**CPRE CHERWELL DISTRICT COMMITTEE COMMENTS ON OUTLINE PLANNING APPLICATION
- 22/01488/OUT – OS PARCEL 5616 SOUTHWEST OF HUSCOTE FARM AND EAST OF
DAVENTRY ROAD, BANBURY**

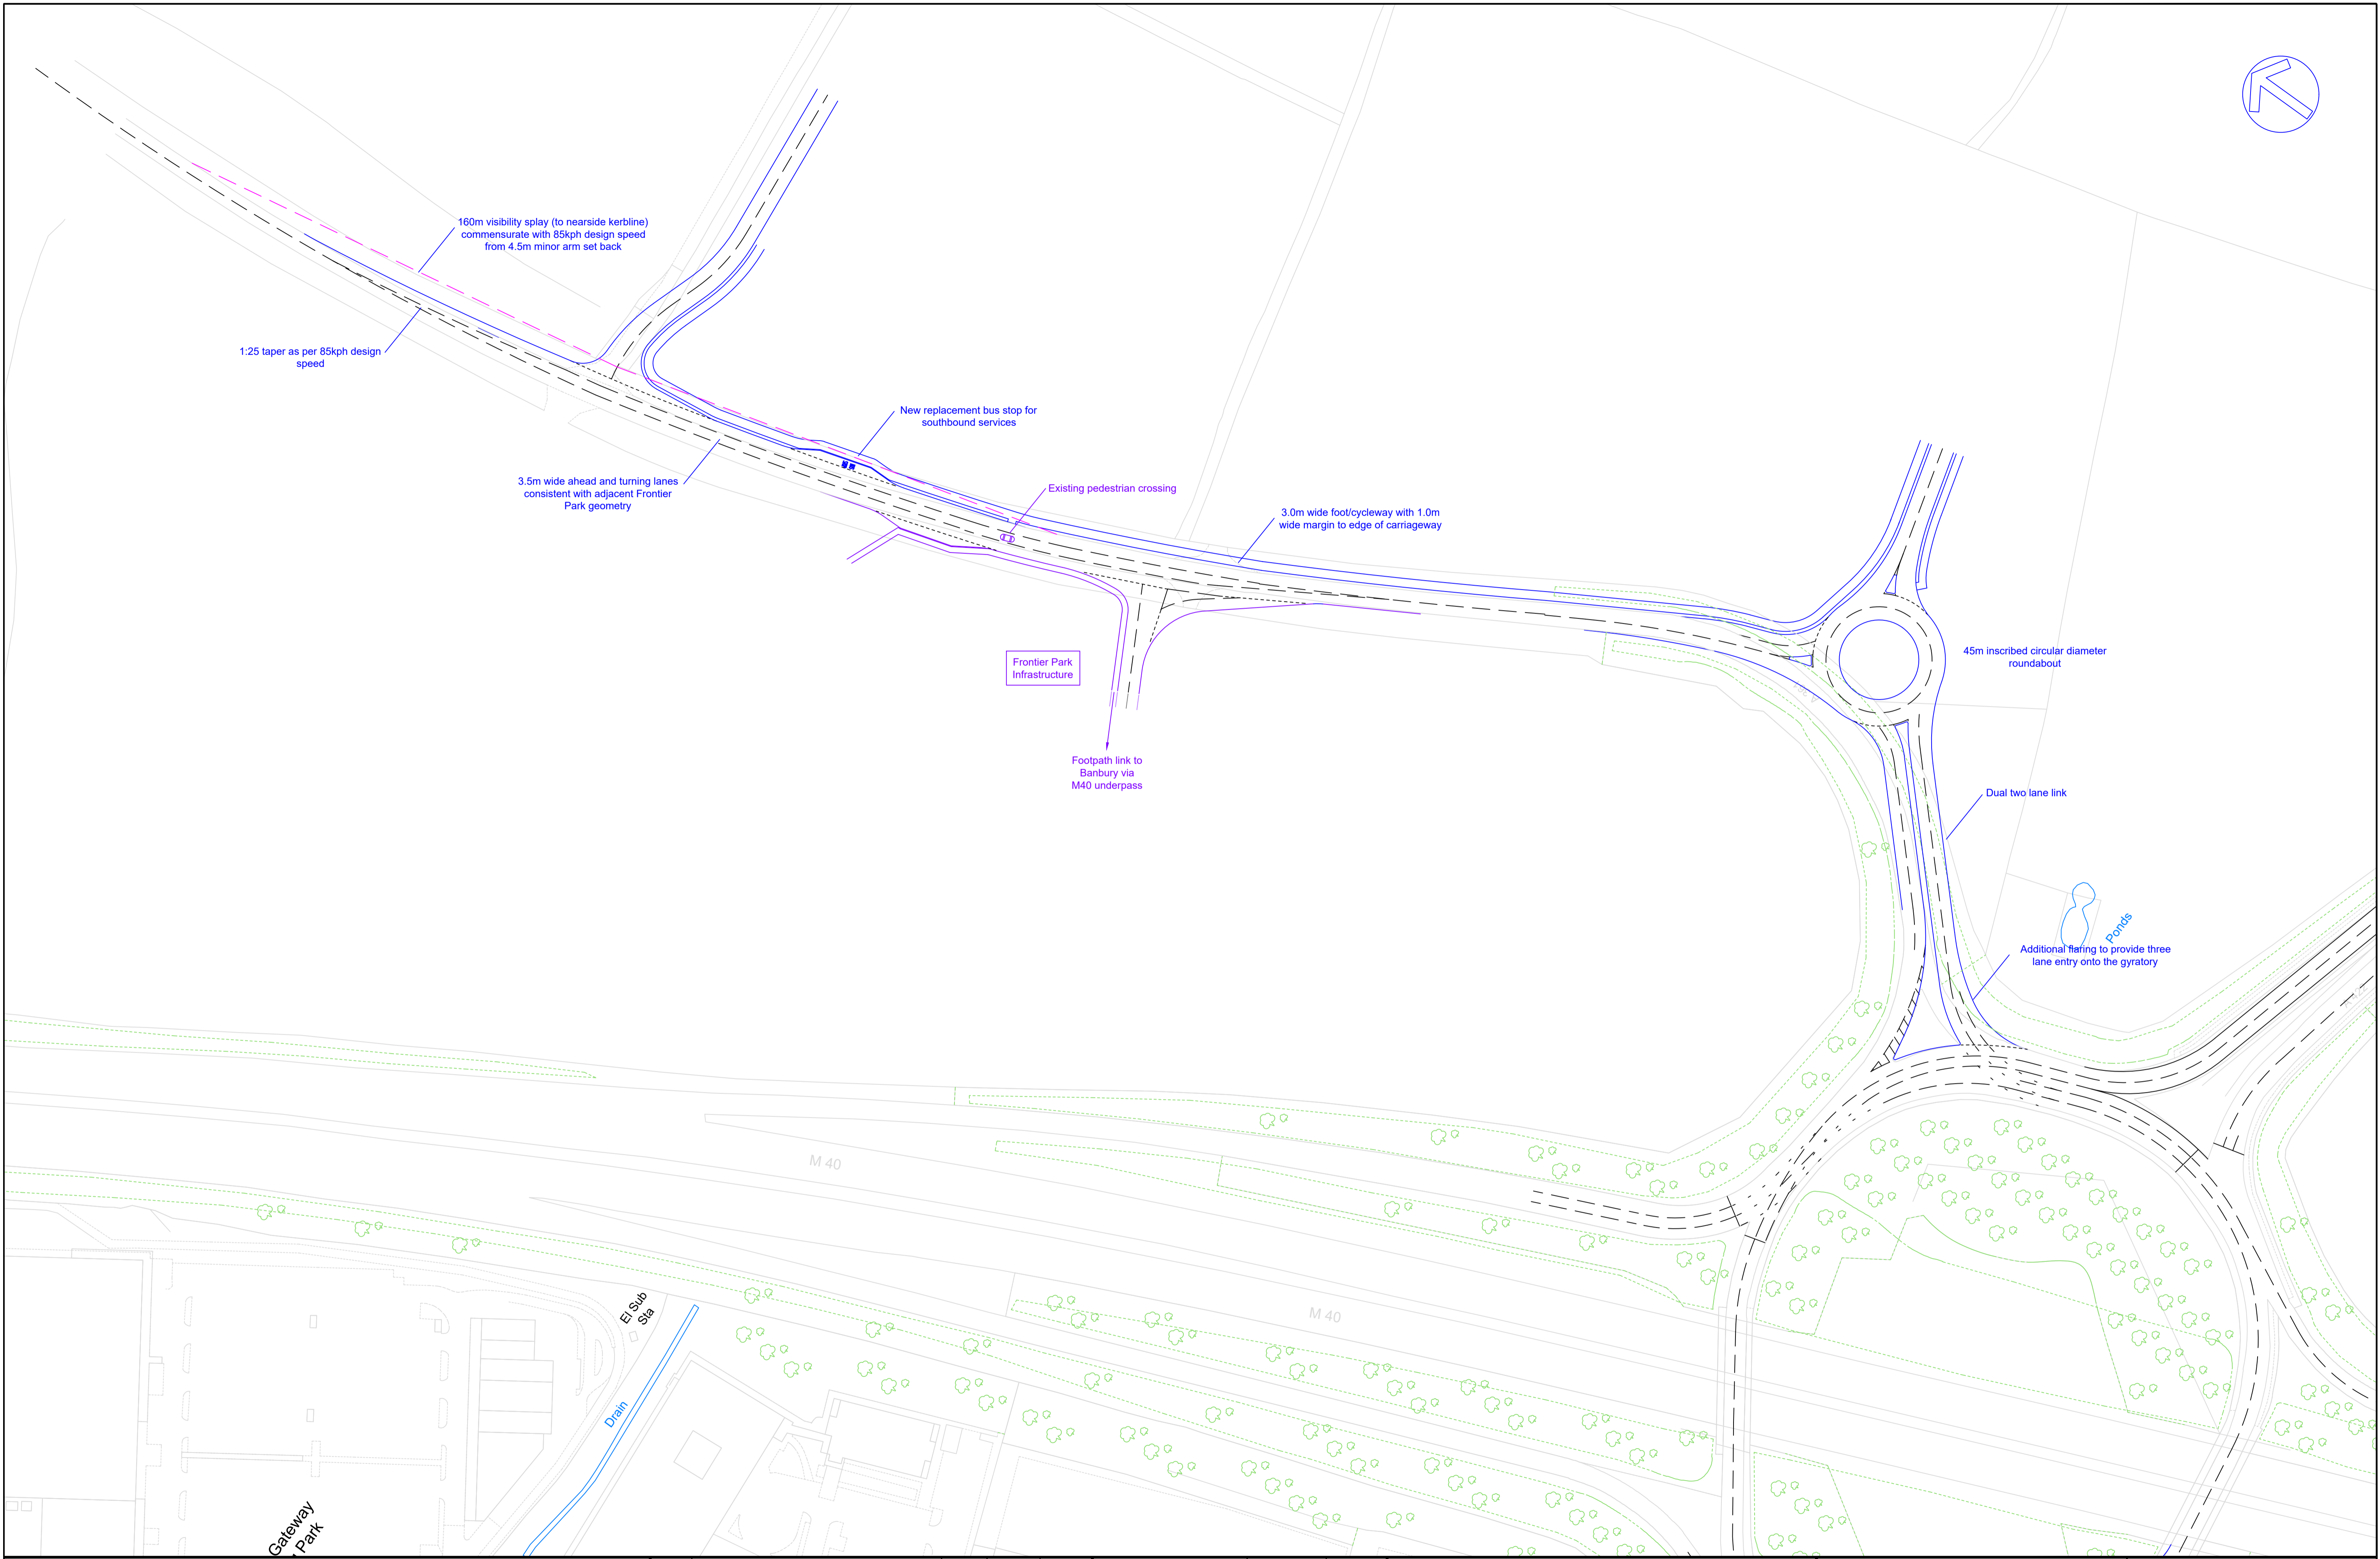
In their consideration of this proposal, Oxfordshire County Council have quite rightly suggested that the proximity of the proposed exit roundabout from the site at a distance of 100m from the J11 M40 interchange poses significant issues in terms of safety and traffic congestion at J11 and surrounding access roads. In conjunction with the extra traffic load anticipated from Frontier Park together with anticipated HS2 traffic, the extra traffic load in the vicinity of the already heavily overloaded J11 would be unsustainable.

1. The major access point to the A361 would be within 100m of the junction itself on a 90 degree curve.
2. The increase in traffic on this route that is anticipated from the already approved Frontiers Park warehouse development plus anticipated HS2 traffic.
3. Even without the wholly inappropriately sited roundabout there would be three entry and exit points to major warehouse sites within a few hundred yards of the J11 of the M40 with one, at this stage, proposed to be on a tight curve. This can only represent a significant safety hazard let alone the significant potential for traffic build up along that stretch of road.

Likewise, the traffic elements of the proposal have been grossly underestimated (or played down), particularly as we have yet to experience the impact on an already overstretched local road system in and around J11 of the M40 of the Banbury 15 site and HS2 activity. In particular, the proposal of a roundabout 100m from J11 is unbelievable and should be grounds enough itself to reject the application out of hand.
